REF: AS12069.210310.L1.1

16 March 2021

**AS12069 WROXTON MOTO X TRACK****Noise Impact Assessment Review**

The 'Noise Impact Assessment' submitted with an application to Cherwell District Council for Wroxton Motocross Track, Banbury, has been referred to us at Clarke Saunders Acoustics for technical review.

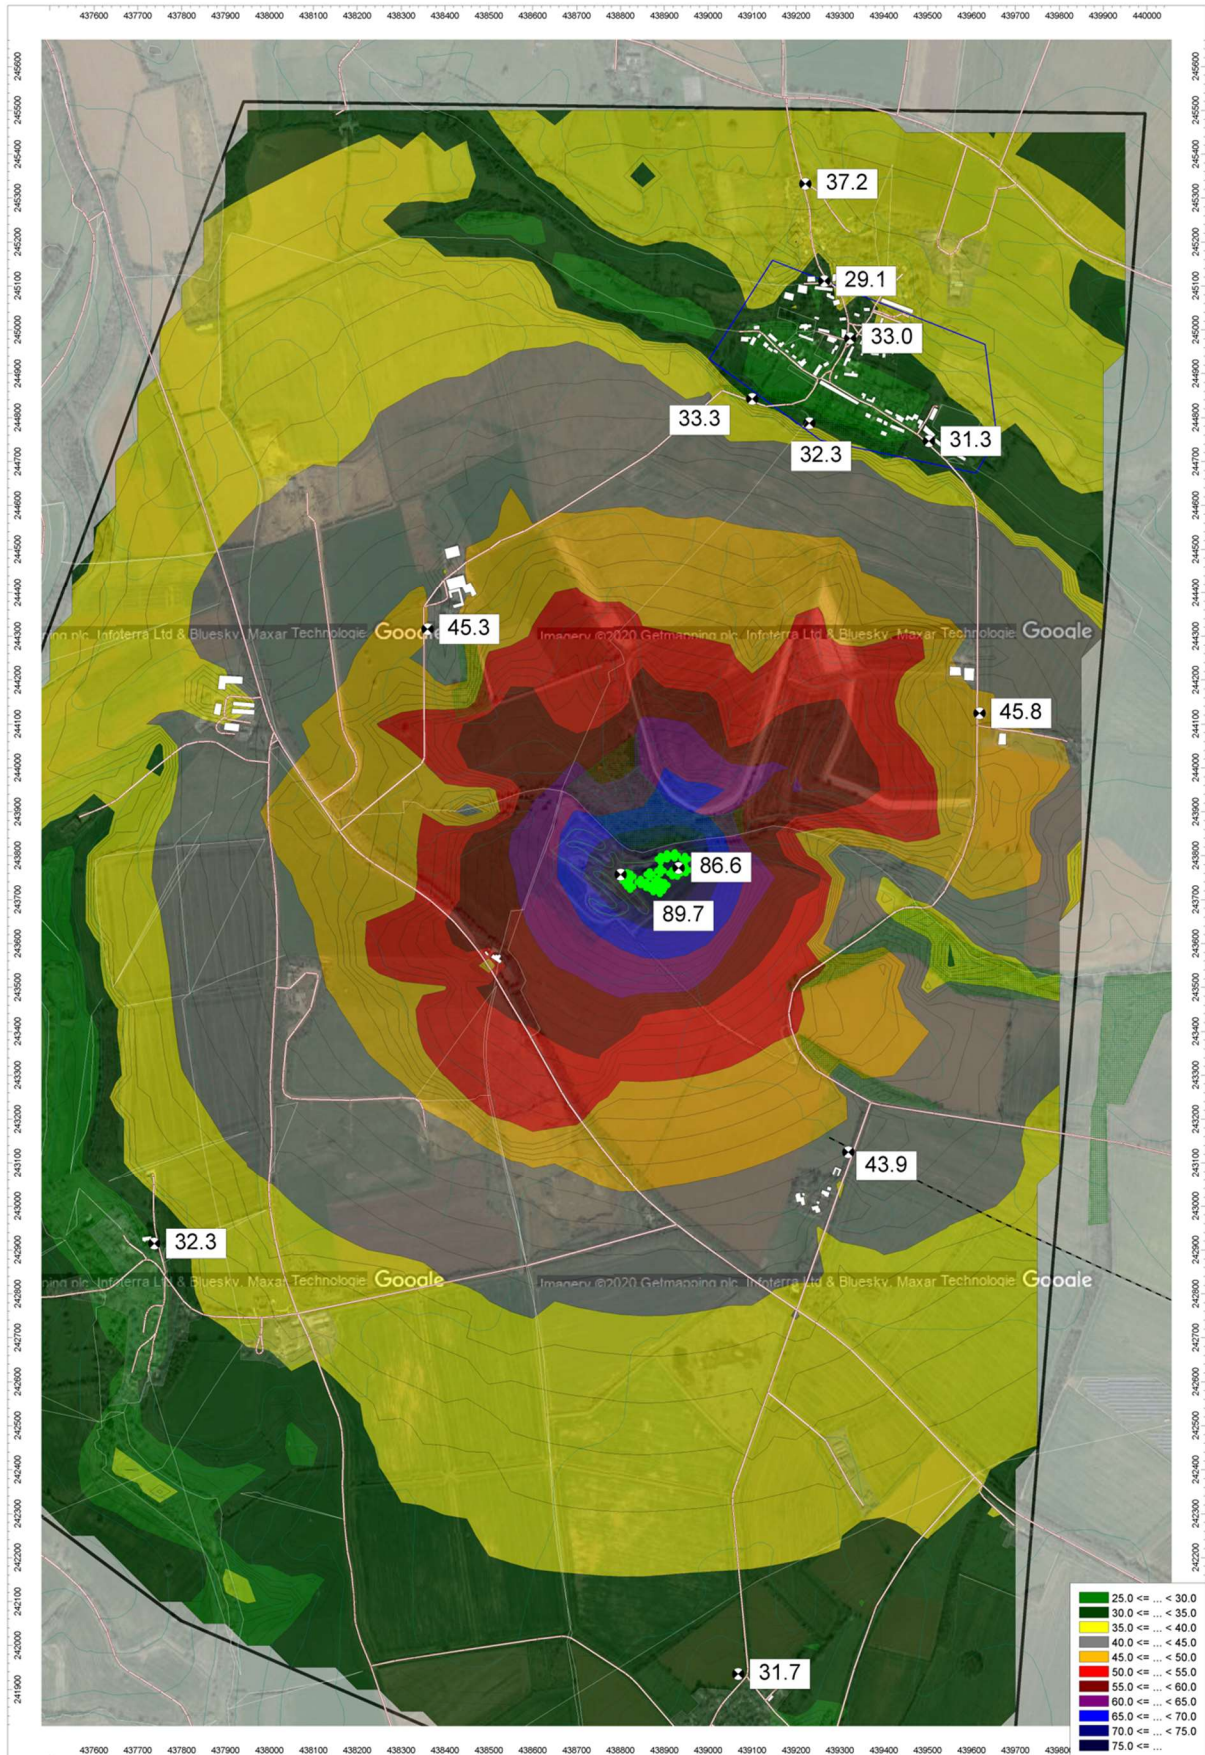
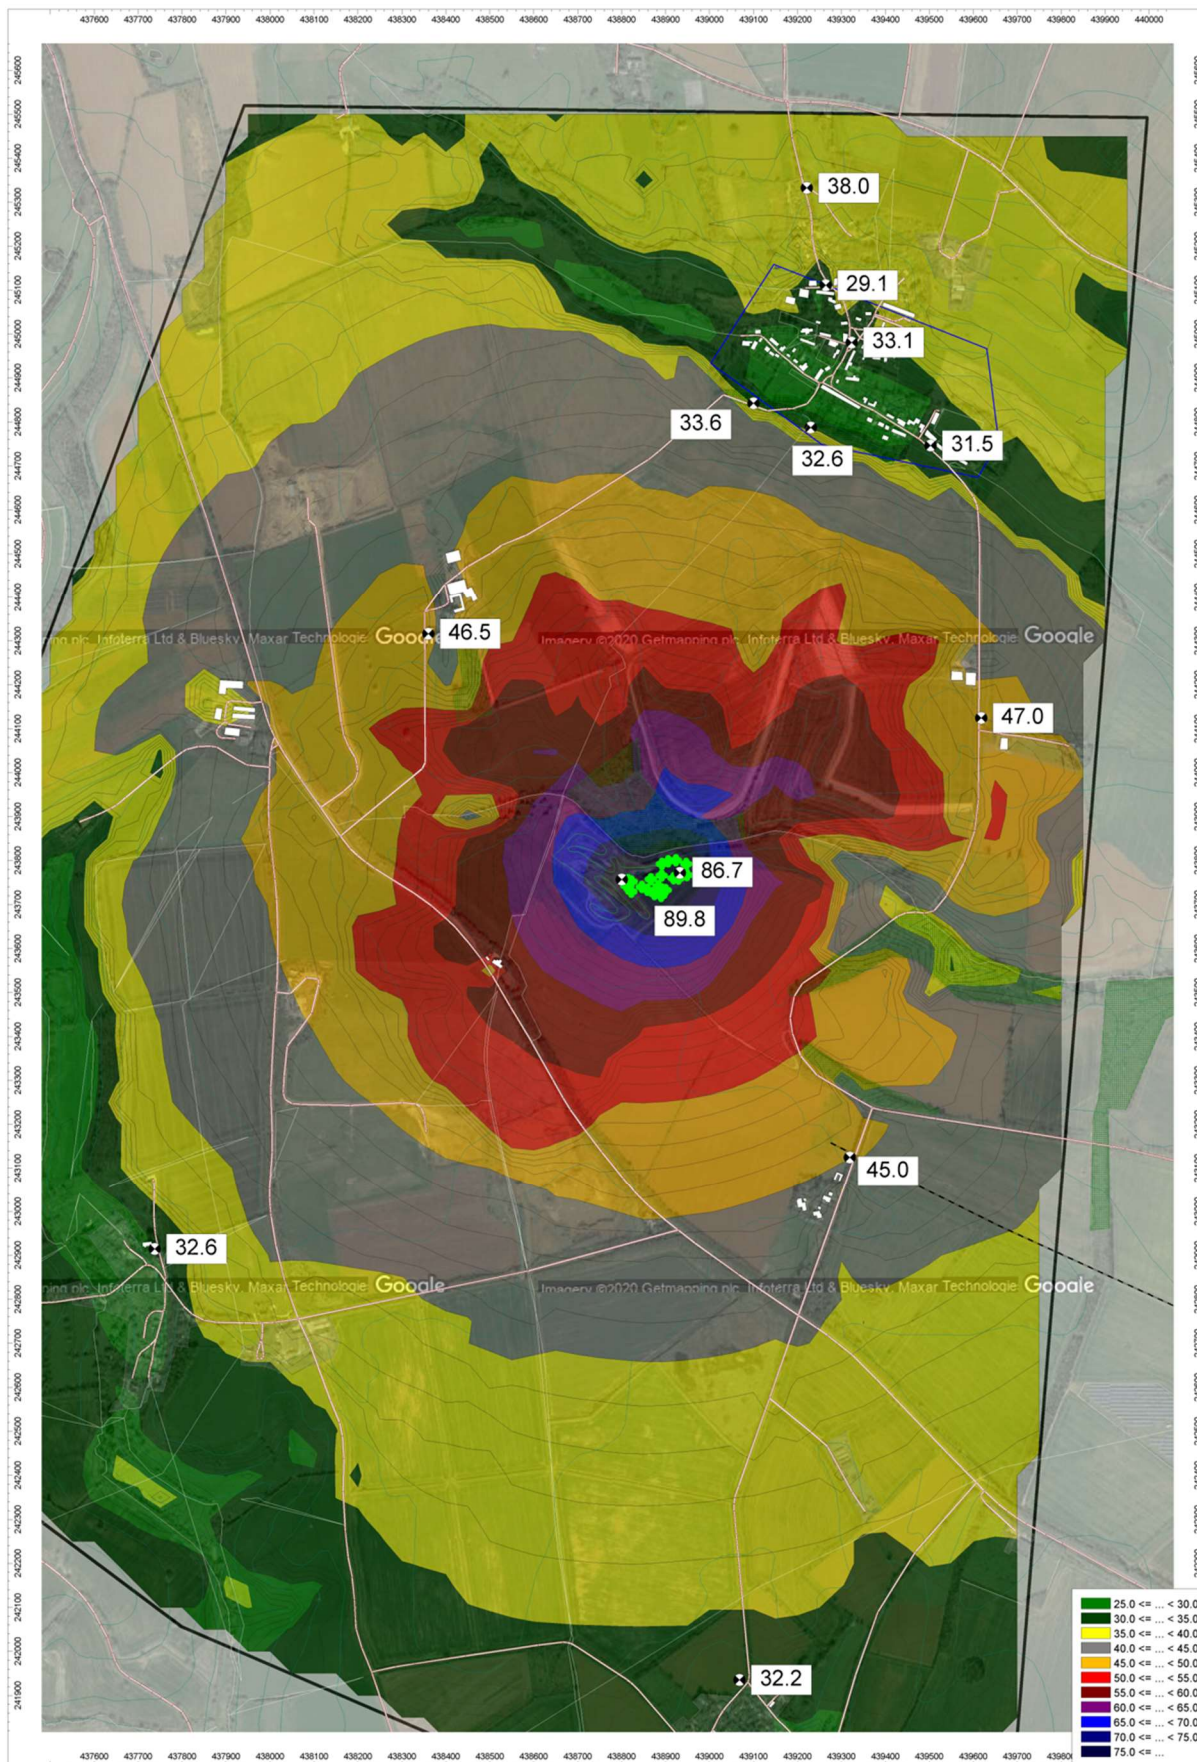
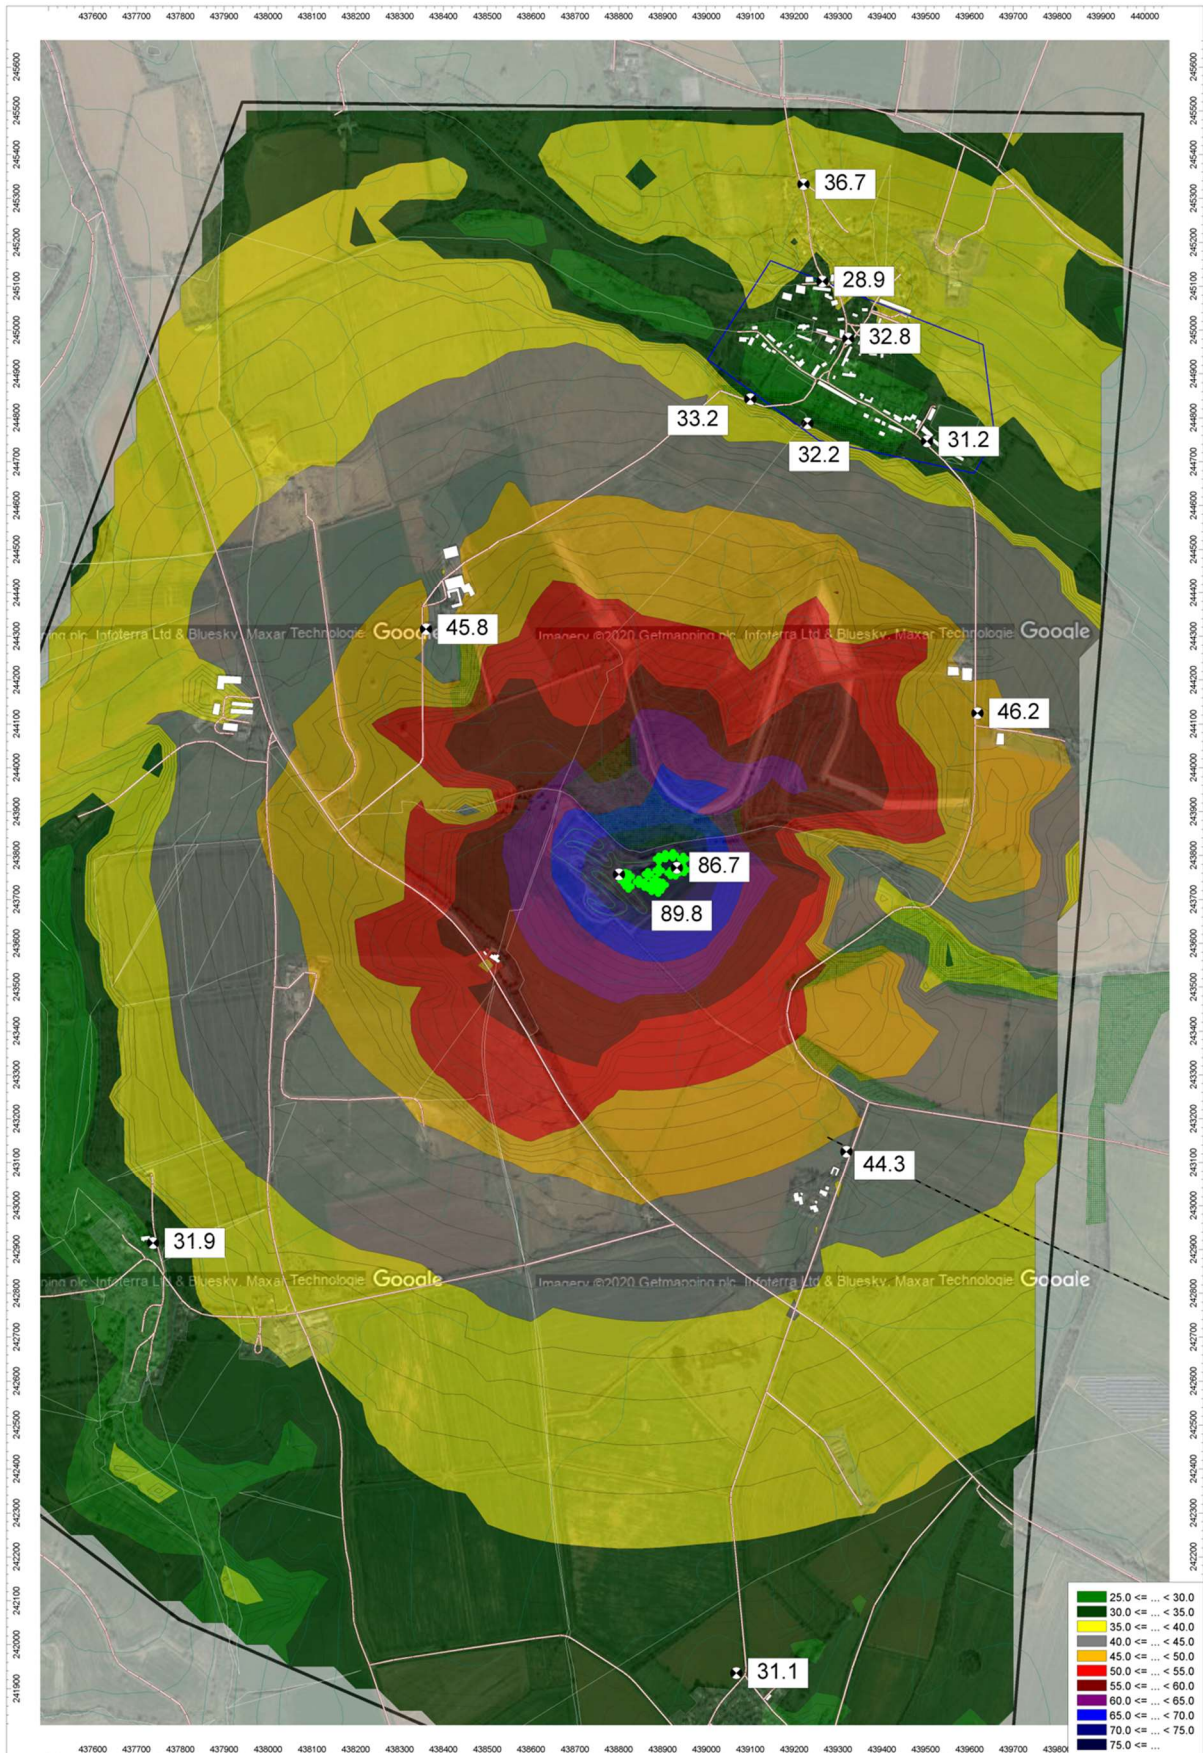
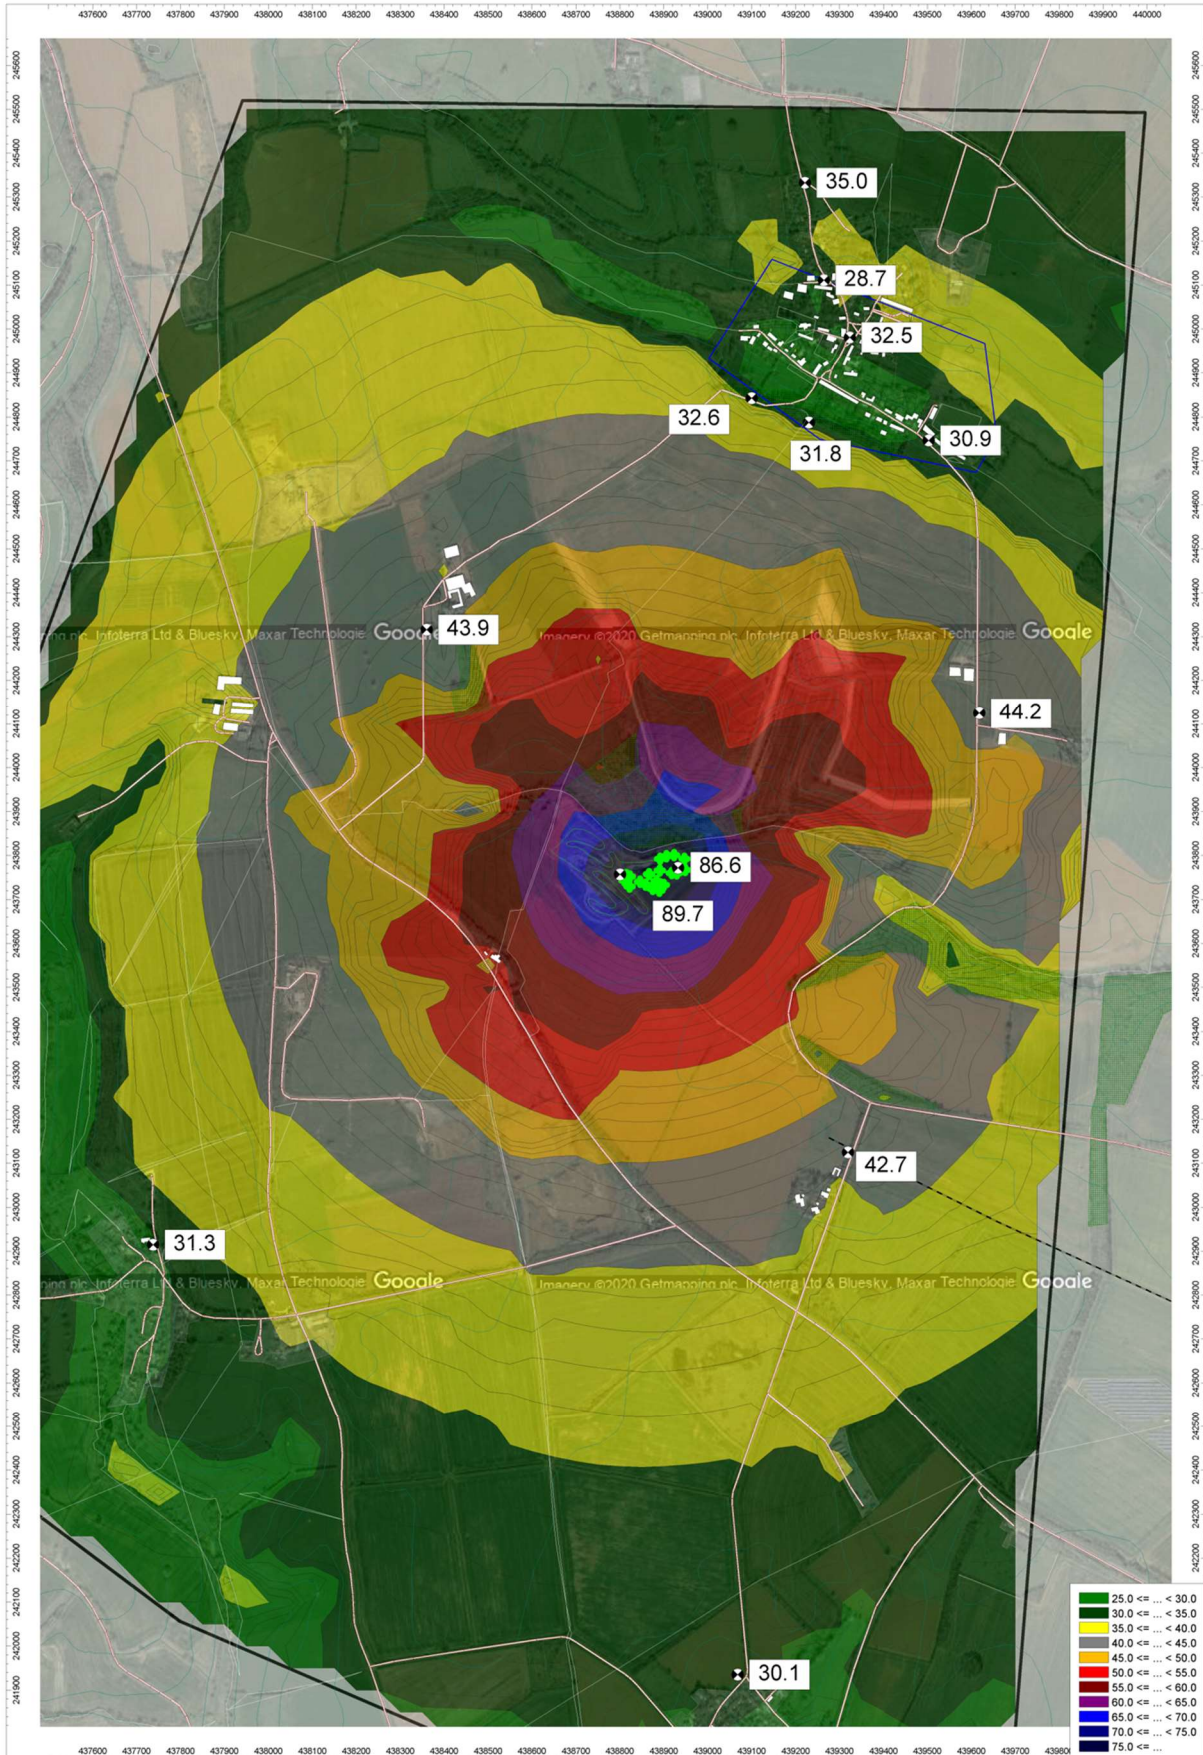
Despite the computer noise modelling presentation of the results, the report submitted describes a very simplistic set of assumptions which can't be relied on to describe motocross noise propagation with any level of precision or reliability without any consideration of these fundamental factors.

The landform of the area places parts of Hornton, for example, in a location which receives a diffracted wavefront which, especially with a southerly wind vector, focusses low frequency exhaust noise to produce higher levels than some locations closer to the track. When combined with receptor locations at which otherwise prevailing background levels are particularly low, the resultant impact will be particularly noticeable. The submitted report contains none of this level of detail or nuance.

No consideration has been given to source directivity in the noise modelling prediction either. With the strong directivity of exhaust noise the orientation of the machines and hence the track circulation orientation become significant factors. This becomes even more significant when taking into account the undulating track features, resulting in increased power output from the engines which at times are significantly higher than the local ground level when airborne over jumps.

Finally, but perhaps most significantly the influence of weather conditions on long range sound transmission is the most important variable of all, having much more influence than variation in number or types of vehicle, for example. The effect must be a factor in the discussion of impacts, numbers of days' exposure, which of the receptors are the most critical with respect to prevailing wind conditions and so on. The author states "*these levels wouldn't be particularly affected by different weather conditions, strong winds would not cause an increase in levels at receptors in the direction of the wind, but would actually benefit those in the opposite direction.*"

There is no reference to prevailing or typical conditions, or the conditions under which the worst-case impact occurs (and the statistical rate of recurrence of those conditions). Distance propagation calculations are prone to significant error if they are not tested and corrected under different meteorological conditions. Any attempts at 'crude predictions' provide no meaningful insight. The biggest variable in motorsport noise assessment is the weather, which dramatically affects the propagation of both activity noise and the ambient noise against which it is assessed, and insufficient consideration has been given to this factor.

Historical weather data shows records a northerly wind on the day of the noise survey, with the implication that noise propagation towards Hornton would have been lower than with a more typical prevailing wind, which would have a southerly component. When the wind speed gradient is aligned with the direction of sound propagation it effectively imparts 'top spin' to the propagating wavefront which would effectively undermine the screening influence of the intervening hill between the circuit and the village of Hornton.
